OXFORDSHIRE COUNTY COUNCIL'S INTERIM RESPONSE TO CONSULTATION ON THE FOLLOWING DEVELOPMENT PROPOSAL

Application no: 23/02098/OUT

Proposal: Outline application, with all matters reserved, for a multi-phased (severable), comprehensive residential-led mixed use development comprising: Up to 215,000 square metres gross external area of residential floorspace (or c.1,800 homes which depending on the housing mix could result in a higher or lower number of housing units) within Use Class C3/C4 and large houses of multiple occupation (Sui Generis); Supporting social infrastructure including secondary school/primary school(s) (Use Class F1); health, indoor sport and recreation, emergency and nursery facilities (Class E(d)-(f)). Supporting retail, leisure and community uses, including retail (Class E(a)), cafes and restaurants (Class E(b)), commercial and professional services (Class E(c)), a hotel (Use Class C1), local community uses (Class F2), and other local centre uses within a Sui Generis use including public houses, bars and drinking establishments (including with expanded food provision), hot food takeaways, venues for live music performance, theatre, and cinema. Up to 155,000 net

Figure 16.4: Overall site drainage catchments

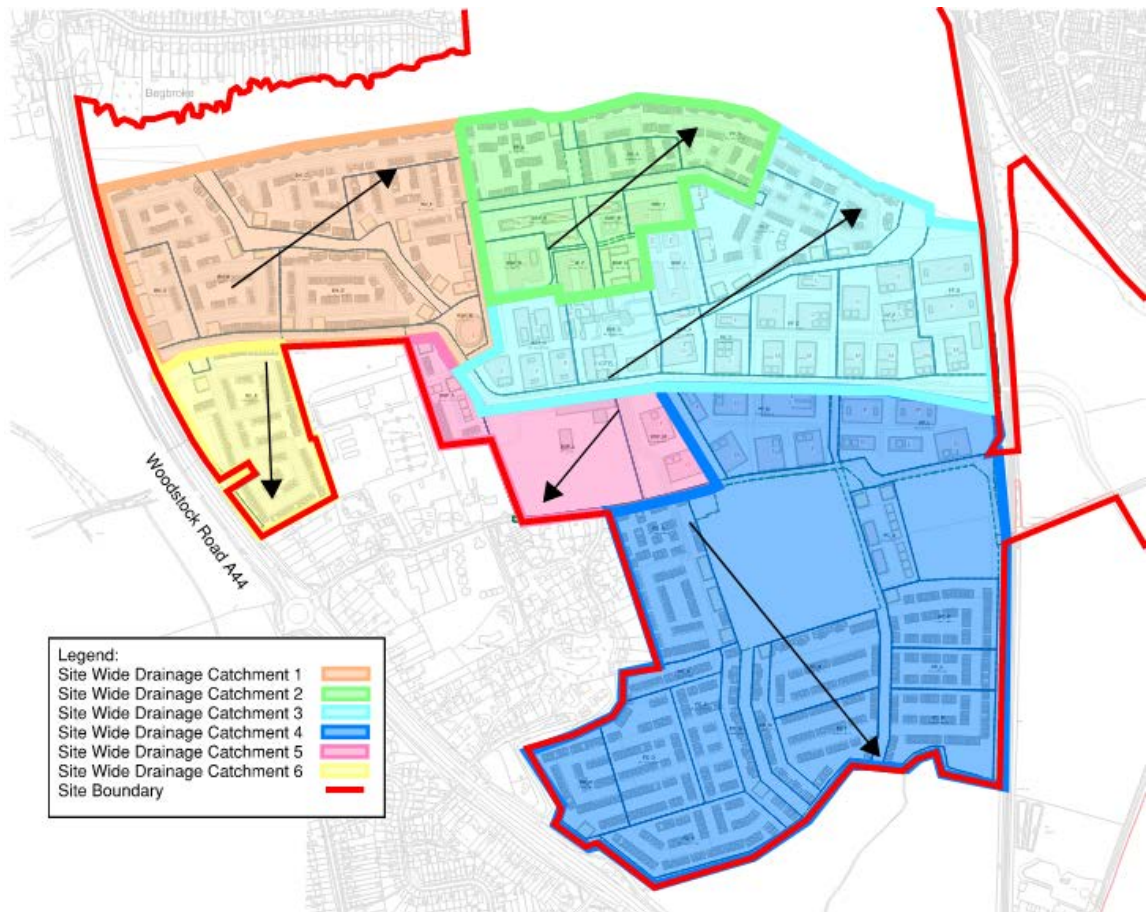
Table 2--5 makes reference to existing catchments and their proposed outfalls, its unclear where these catchments are as they are not shown on plan. Provide surface water catchment plan stating the catchments and the locations of the outfalls and discharge rates.

The yellow catchment along Woodstock Road is shown to discharge to the same outfall which is currently facing flooding issues, this is the same outfall as PR9. Clarification is required on the exact outfall location as its not shown on plan.

Figure 5—3 Overall Site drainage catchments

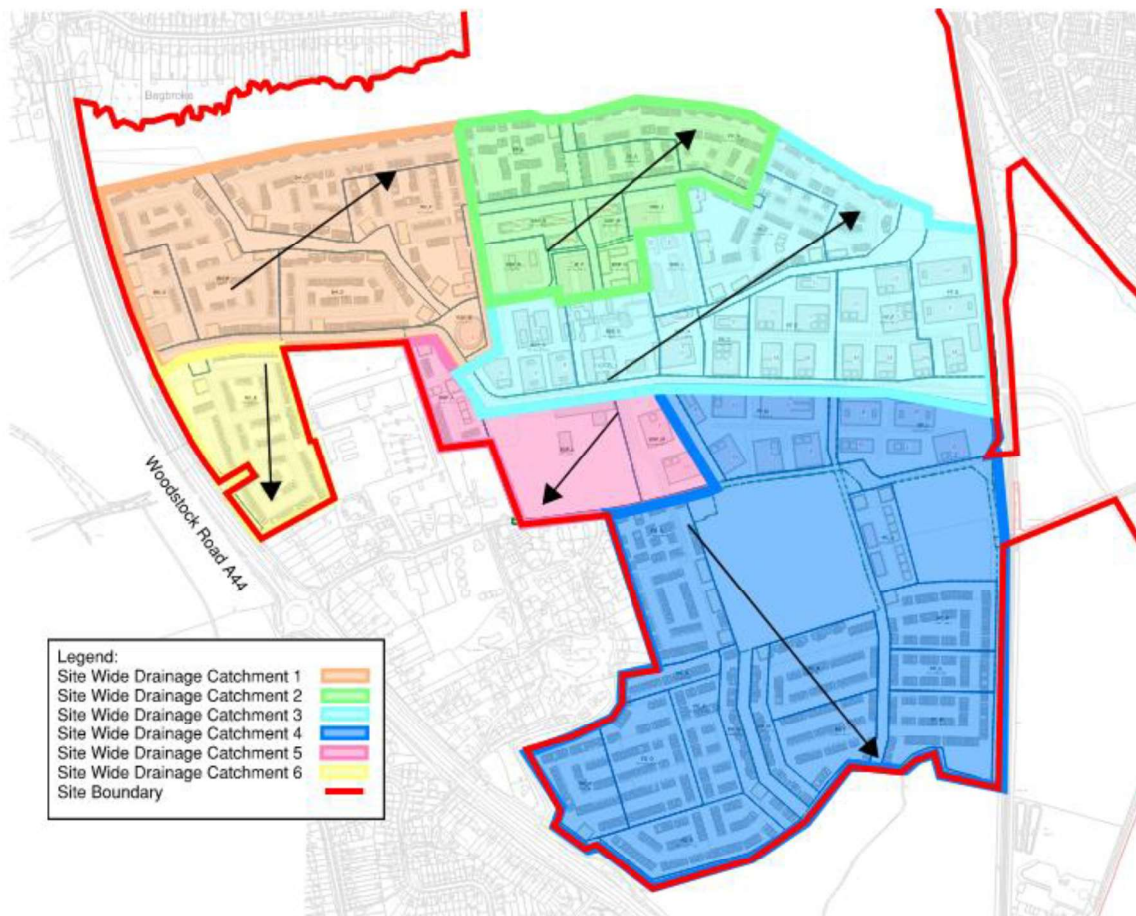
Surface water catchment plan to be provided, showing the extent of the impermeable areas and stating the area after allowing for 10% urban creep.
